**APPLICATION BY EP WASTE MANAGEMENT LIMITED FOR AN ORDER
GRANTING DEVELOPMENT CONSENT FOR SOUTH HUMBER BANK ENERGY
CENTRE PROJECT**

PLANNING INSPECTORATE REFERENCE NO: EN010107

**SUMMARY OF WRITTEN REPRESENTATION
submitted on behalf of Network Rail
Infrastructure Limited**

**Figure 3.1: HGV designated route plan**

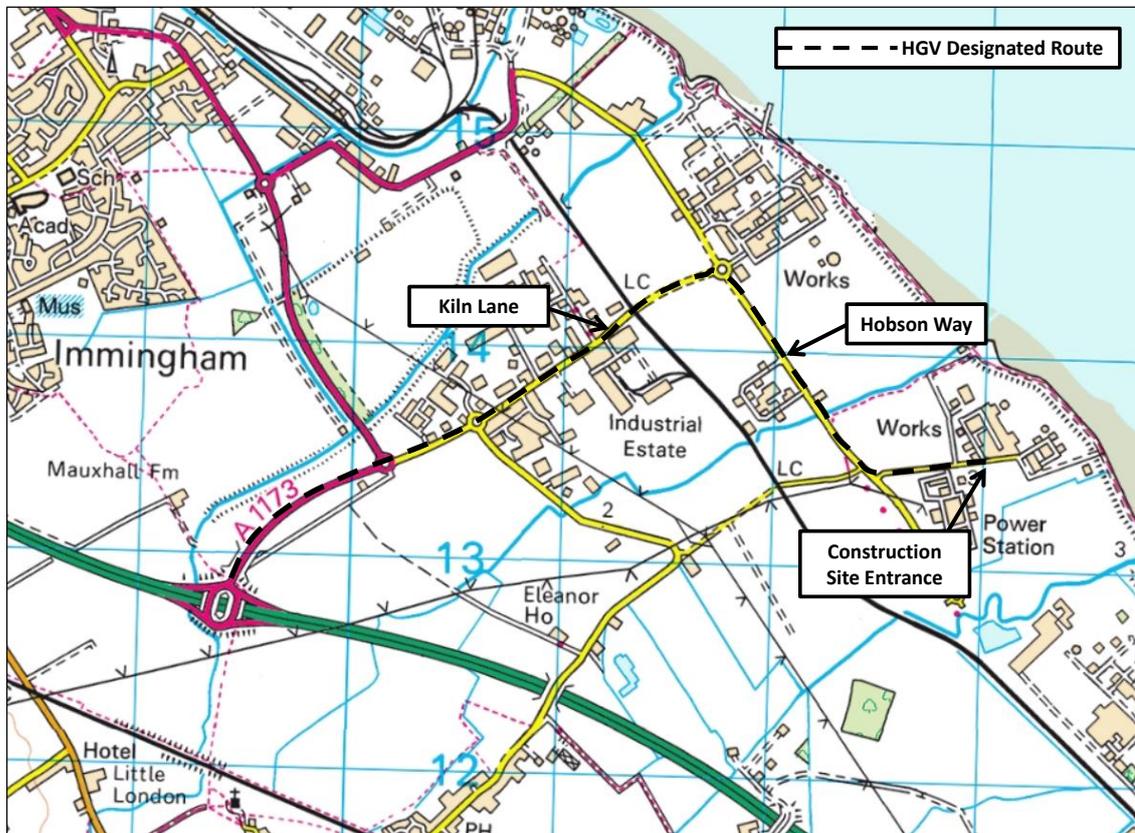
- 2.1 The Applicant notes that employees of the Power Station Site would likely utilise South Marsh Road and Marsh Lane level crossing as the primary means of access to the power station site. The Applicant has also proposed that the Kiln Lane level crossing is included in the designated route providing HGV access to the Proposed Development (**HGV Designated Route**) as referred to in the Transport Assessment¹.

2.3 The application documents make no reference to an alternative route for HGV traffic should Kiln Lane be closed for any reason, for example, to allow upgrade/mitigation works to be completed. Network Rail is concerned about what would happen to the HGV traffic in particular in this scenario, and this is one of the reasons Network Rail has requested that it is consulted on:

2.4 Network Rail is concerned that the Delivery and Servicing Plan, the Operational Travel Plan and the Construction Traffic Management Plan do not limit the number of HGVs using the Kiln Lane level crossing and does not provide a mechanism to re-evaluate the safety of the Kiln Lane level crossing should there be an increase in vehicle numbers beyond those detailed in the Transport Assessment.

- 2.23 Network Rail have suggested an alternative route which does not include the Crossings. This alternative route is via South Marsh Road (east of Hobson Way), Hobson Way (North & Southbound), Laporte Road (North & Southbound) via Queens Road (East & Westbound) onward to Kings Road (East & Westbound) to join the A1173 and then the A180 as shown on the plan attached at Appendix 6. This route is approximately 1.5 miles longer than the HGV Designated Route but utilises a road over a rail bridge to cross the Railway Line on Queens Bridge Road. According to Network Rail's Asset Protection team, Queens Bridge was

- 2.24 Network Rail would like clarification from the Applicant as to why these alternative routes were not selected. The Applicant has not provided a sufficient rationale as to why the most direct route was chosen rather than one that does not include interfaces with the railway.

- (ii) the Applicant will not use or permit the use of South Marsh Road (between North Moss Lane and Hobson Way) and South Marsh Lane level crossing by heavy goods vehicles travelling to or egressing from the authorised development.
